Re. Walmart #835.275 located at: 400 Eubank Blvd NE – PR2

The scope of work for this Administrative Amendment re\view is the for updating of the previous AA#-**SI-2022-00847** for the Walmart building/site signage along with the gas canopy & building to the new updated font and new branding signage.

WALMART STORES, INC. STORE NO. 0835-275	06/02/22
PROJECT: ALBUQUERQUE, NM	PLAN REVISION #2
PROJECT NO. 21694016

Description: This Plan Revision consists of Drawing Sheets **A2 and A2.1** dated **06/02/22**. No specification changes.

SIGNAGE GENERAL NOTES

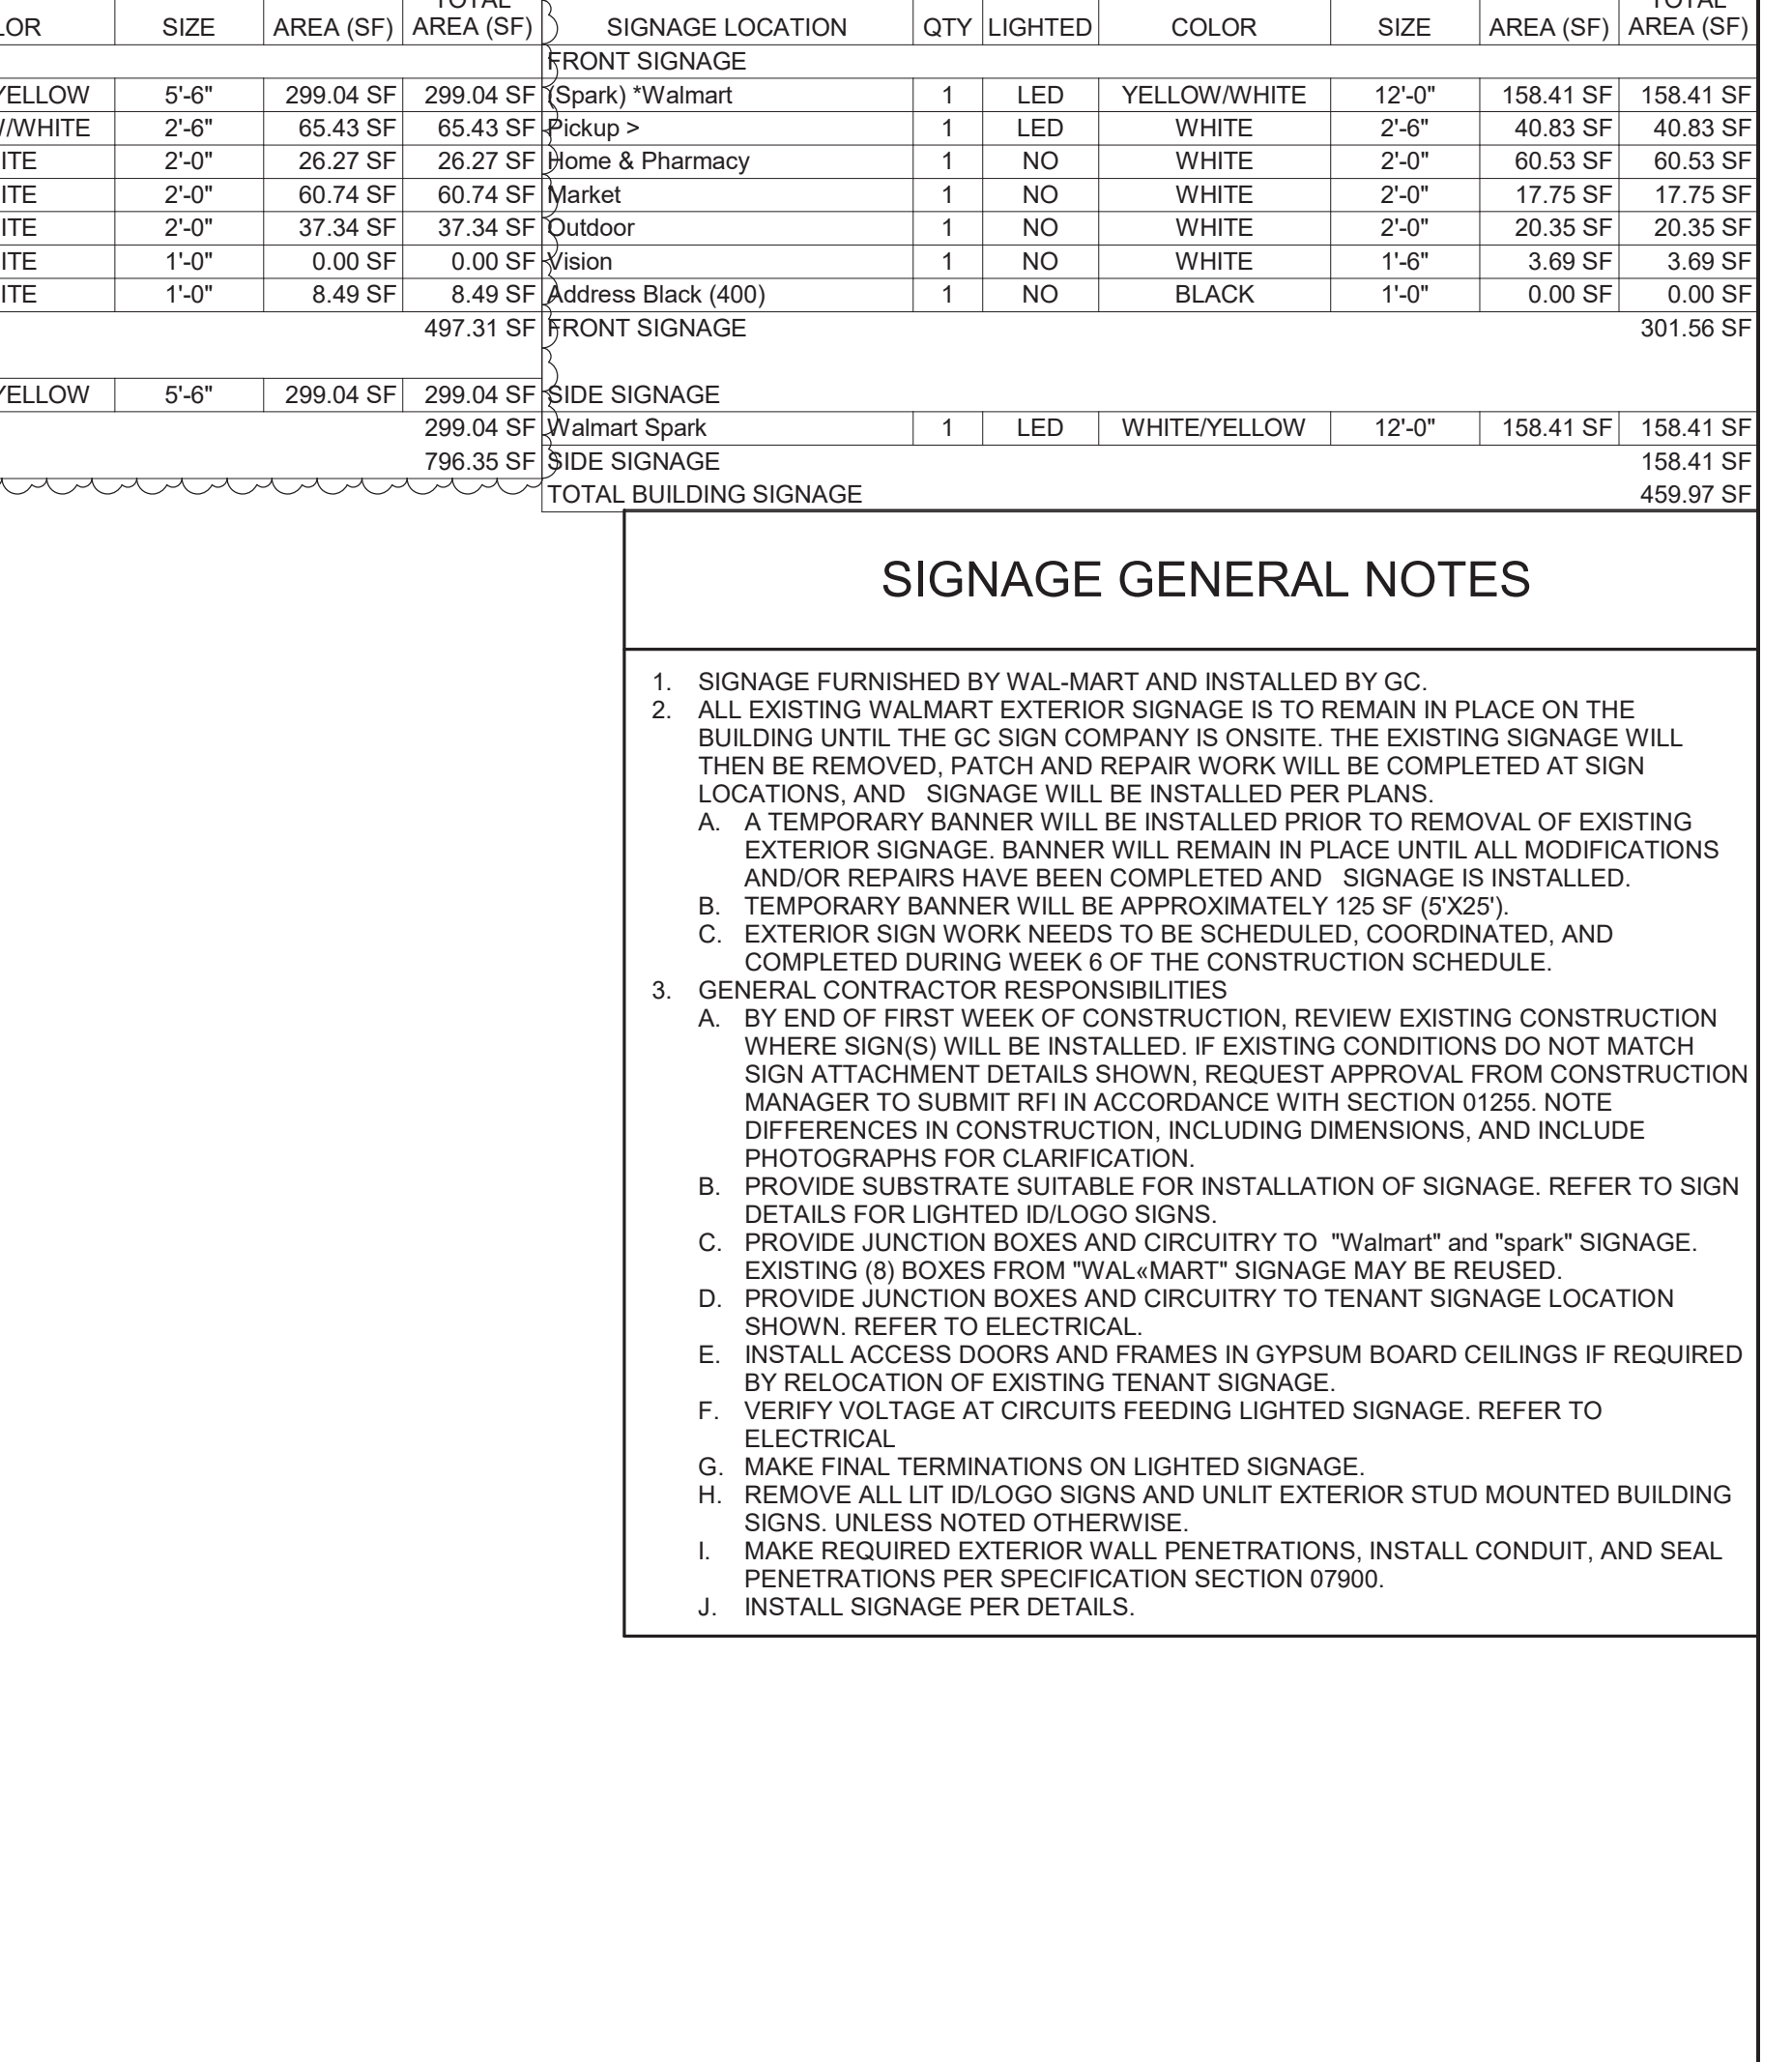
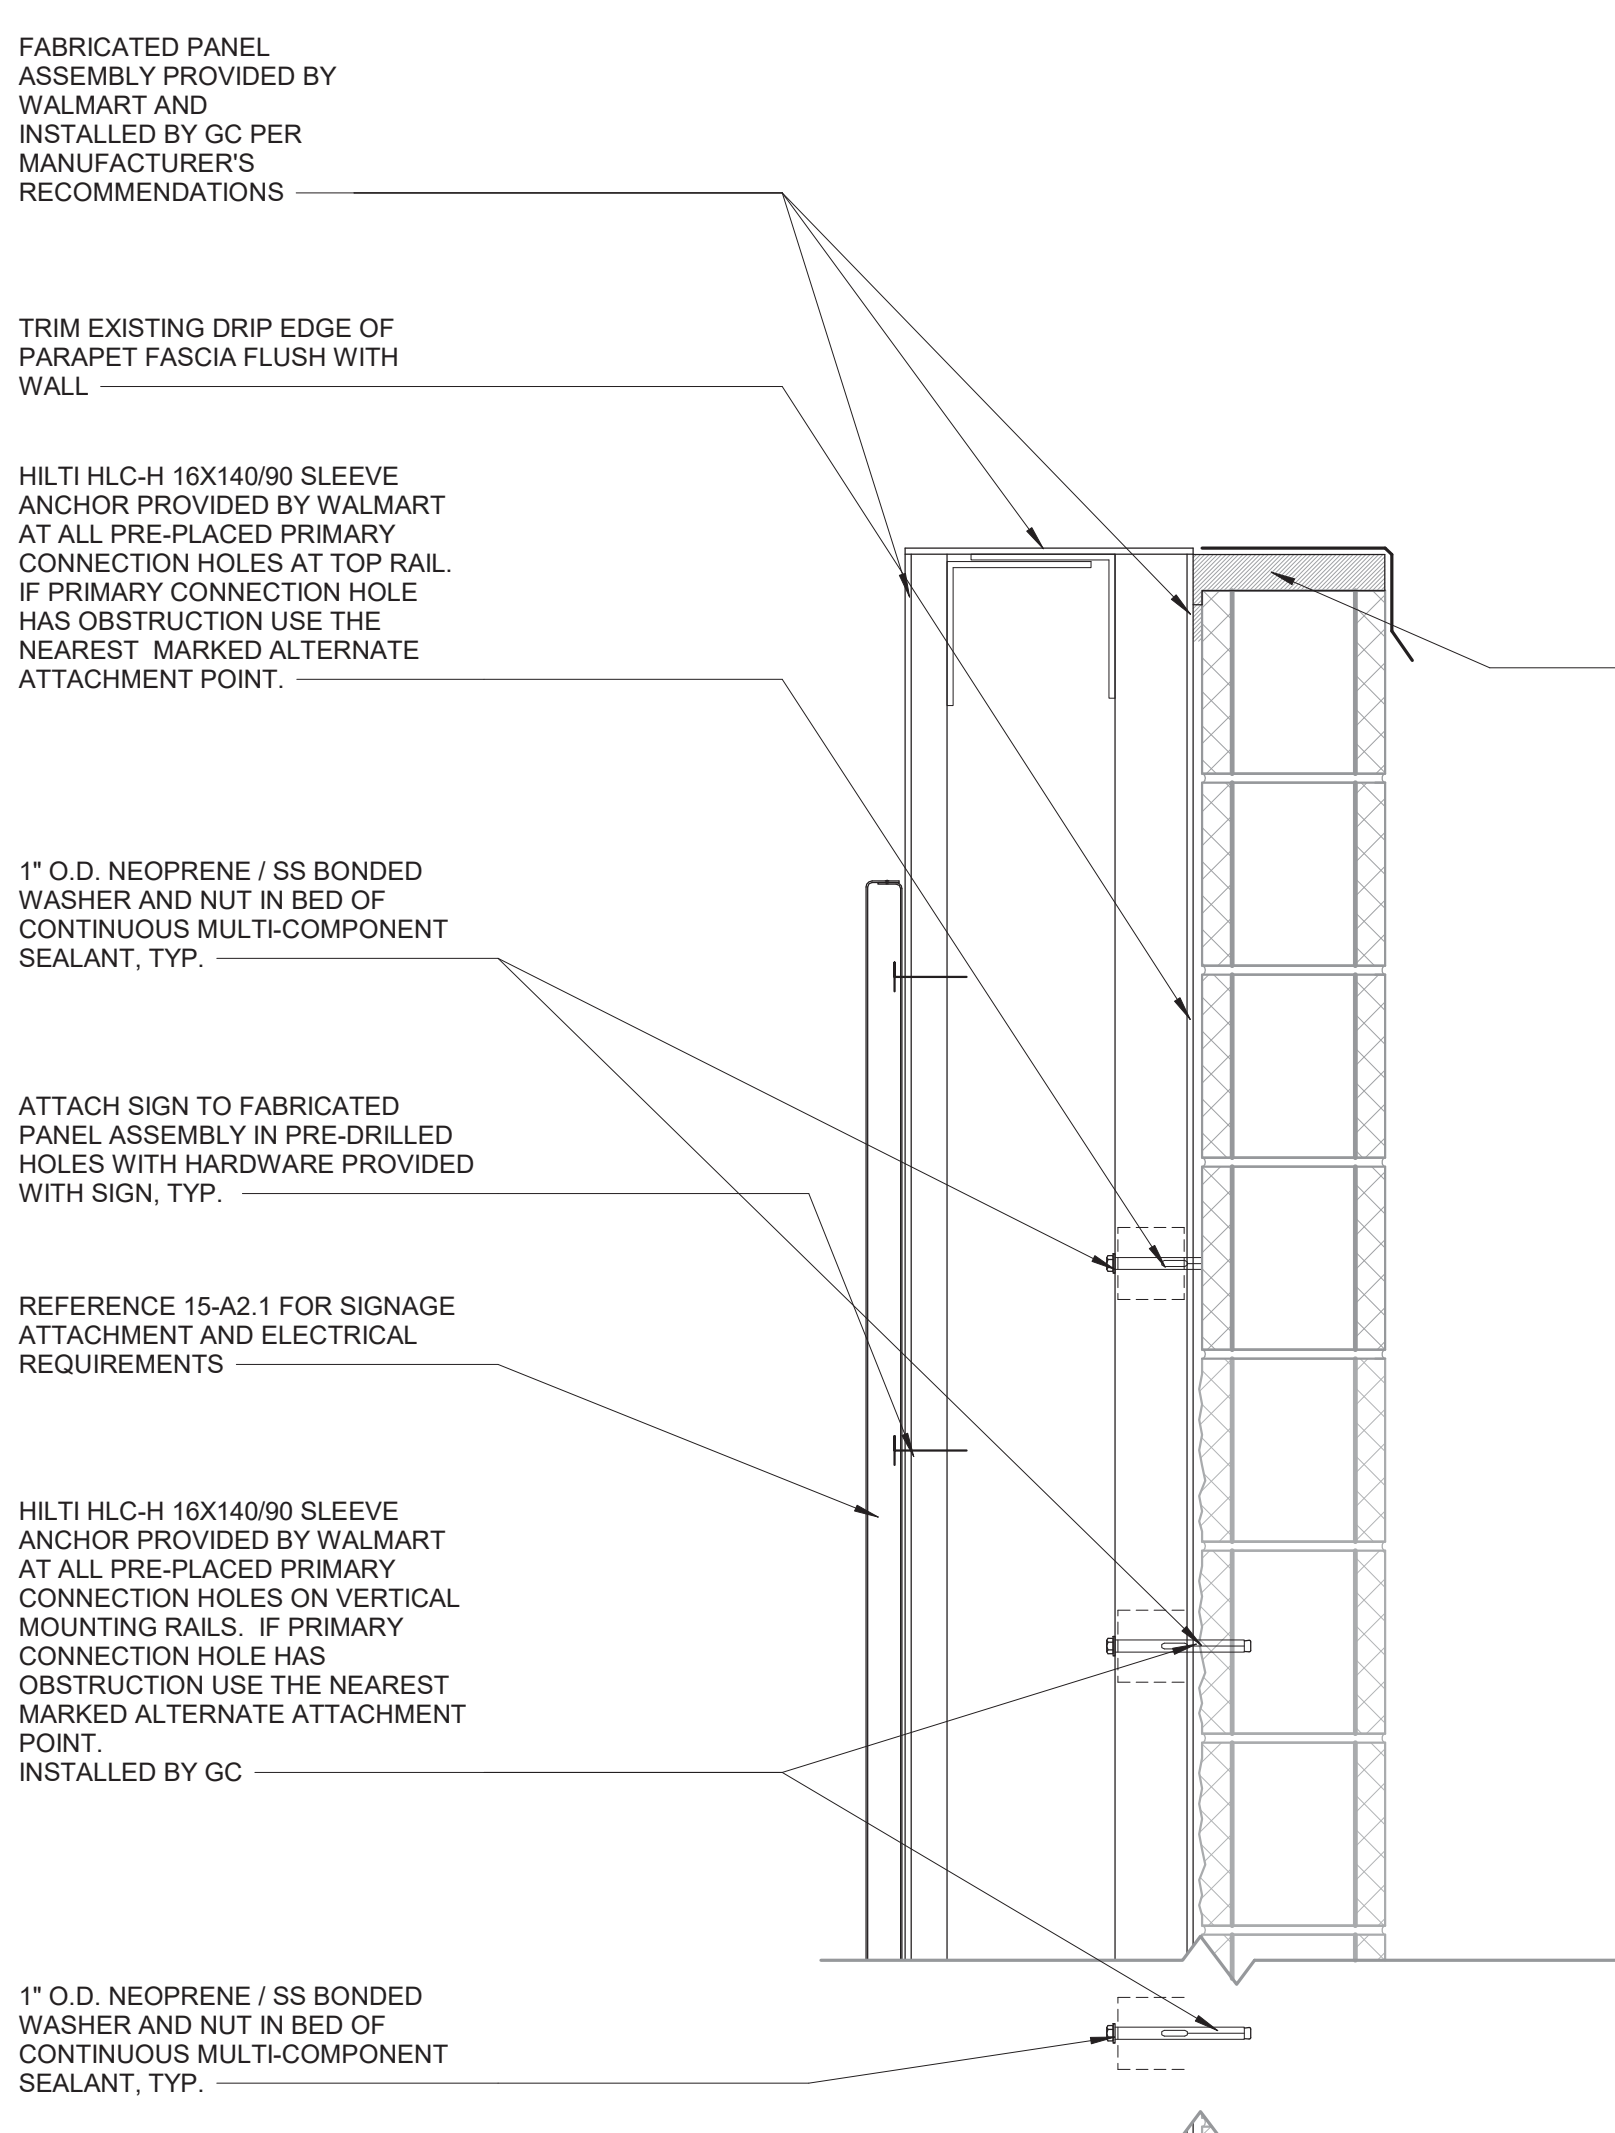
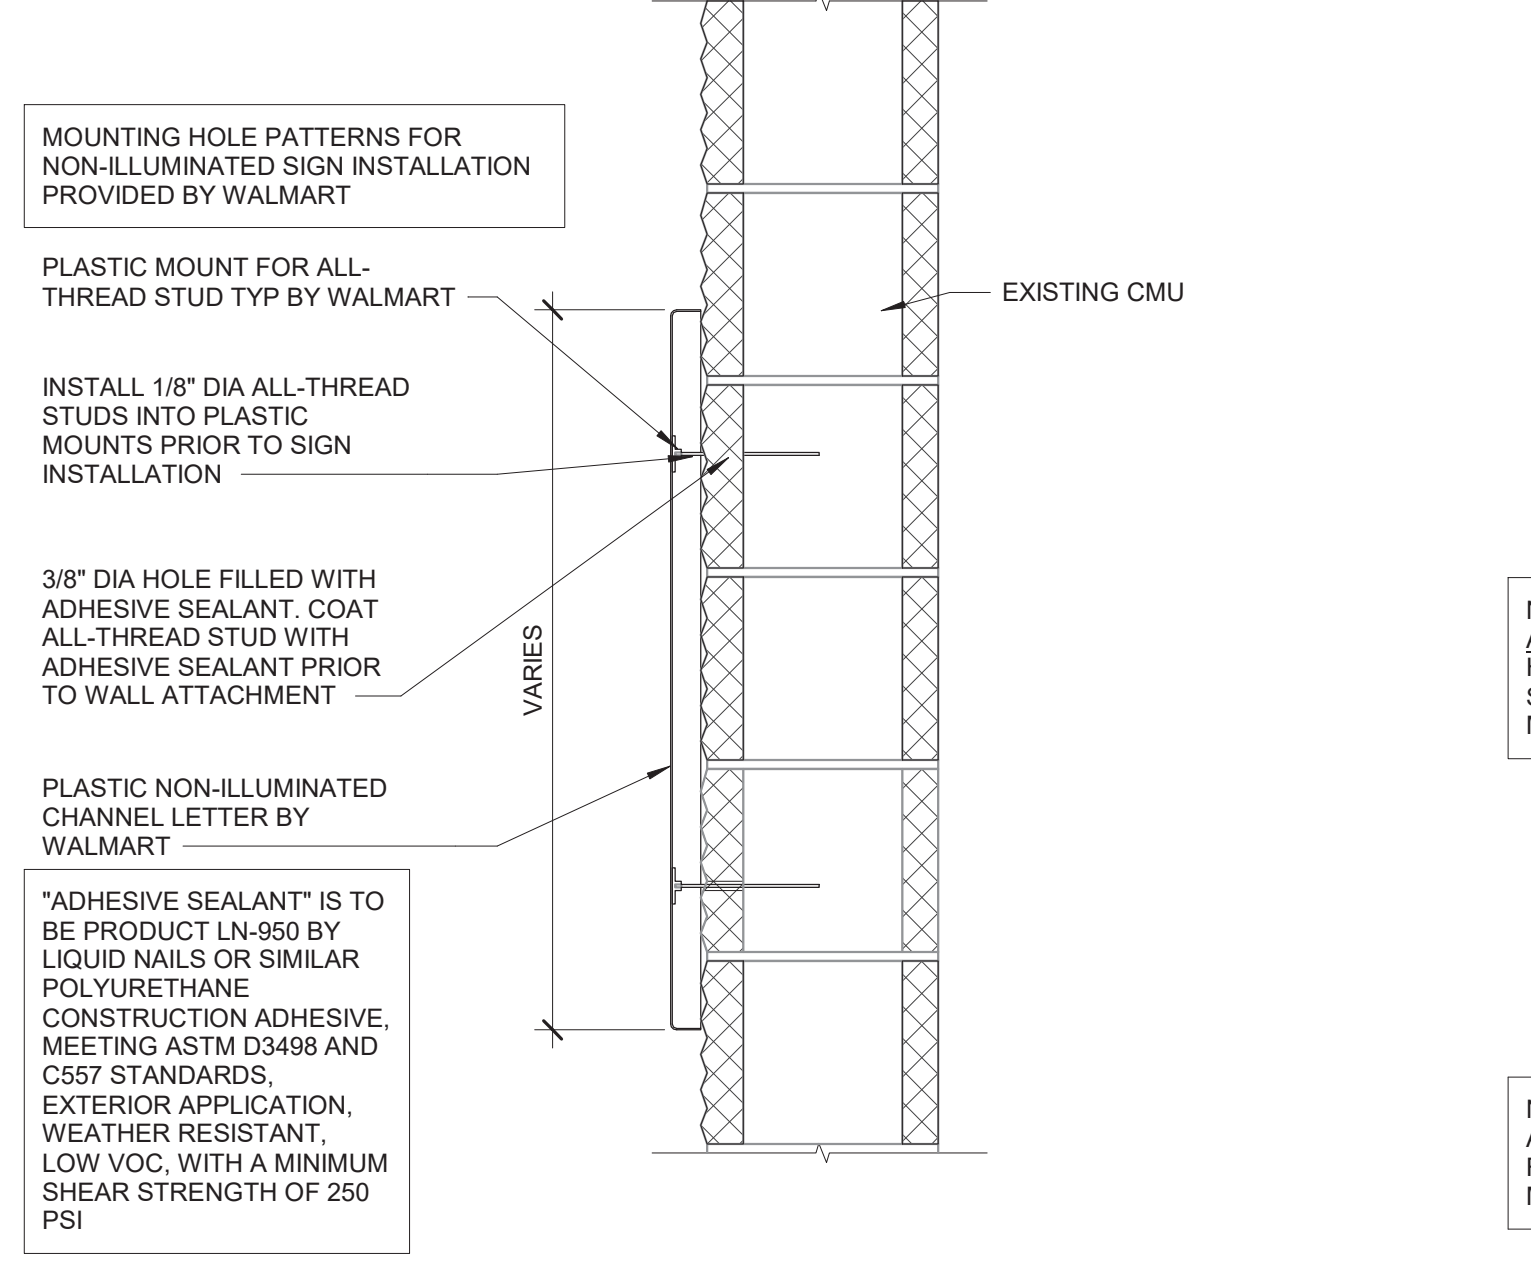
DETAIL 6 – 2'-0" SIGNAGE

1. Revise detail title from "2'-6" SGIANGE" to "2'-6" SIGNAGE". **(CI1)**
2. Revise Outdoor sign with associated notes from 2'-0" to 2'-6". **(CI1)**

DETAIL 11 – WALL PANEL SECTION (V1)

1. Revise section to reflect proper elevation for bolt on sign aligning with existing wall height. **(C11)**

NEW SIGNAGE SCHEDULE

1. Revise Outdoor sign size to 2'-0". **(C11)**

EXISTING SIGNAGE SCHEDULE

1. Revise all information to correspond with current existing conditions. **(C11)**
